Five Estuaries Offshore Wind Farm

**Natural England's Response to the Report on the Implications for European Sites
(RIES) [PD-027]**

Planning Inspectorate Reference: EN010115

03 March 2025

Figure 3.1: Simulated un-impacted (baseline) population size over the 25 years modelled.

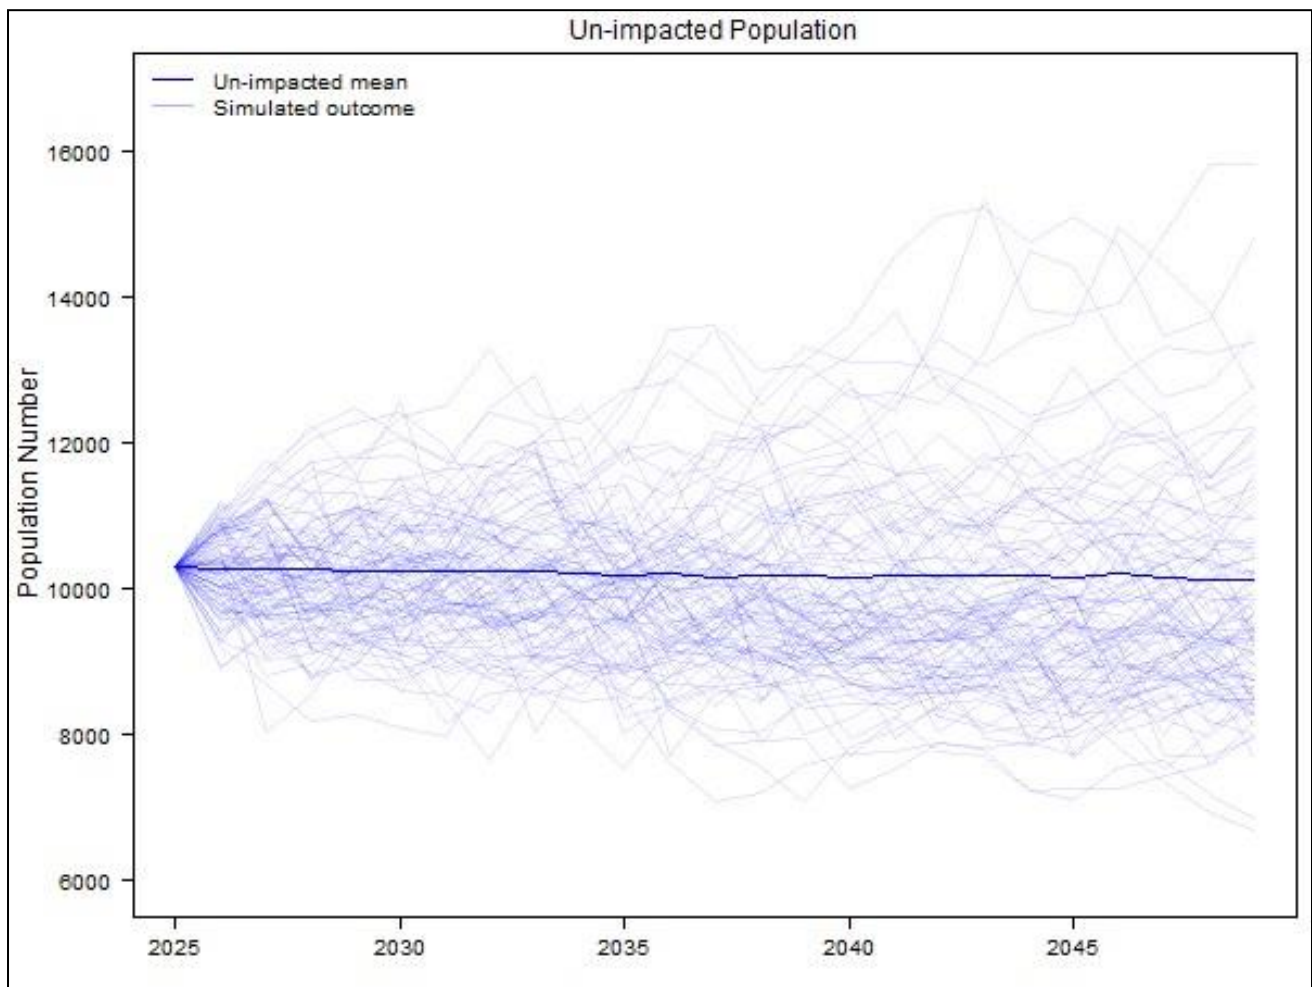
Southern North Sea SAC			
3.2.1	<p><u>Marine Mammal Population Modelling</u></p> <p>QT3.2.1 [To NE] Confirm if the updated iPCoD modelling in [REP5-071] addresses your</p>	<p>Natural England welcomes the addition of the median and 95% Confidence Intervals (CIs) values to the report.</p> <p>However, we note that there is no variation for median, mean and CI values for both species of seals between impacted and unimpacted populations</p>

RIES ID	RIES Question	Natural England Comment	RAG Status
	concerns. If not, confirm what further evidence you consider is needed.	<p>(Tables 5.2.and 5.3). It is our understanding that the iPCoD model runs the simulations 1000 times for each scenario thus there is an expectation that the output values would show some variation. The outputs could potentially be the same if the population size is large (please note, a slight variation is present in the modelling scenarios for harbour porpoise whose population is significantly larger than those of seals), however the starting population for harbour seals is small and even considering a declining population does not demonstrate any level of variation between the impacted and unimpacted populations.</p> <p>In light of this, we have concerns around the variability of the outputs for the project alone and we believe that there is value in undertaking in-combination iPCoD modelling which may indicate a greater level of variation and potential population level impacts warranting further investigation.</p>
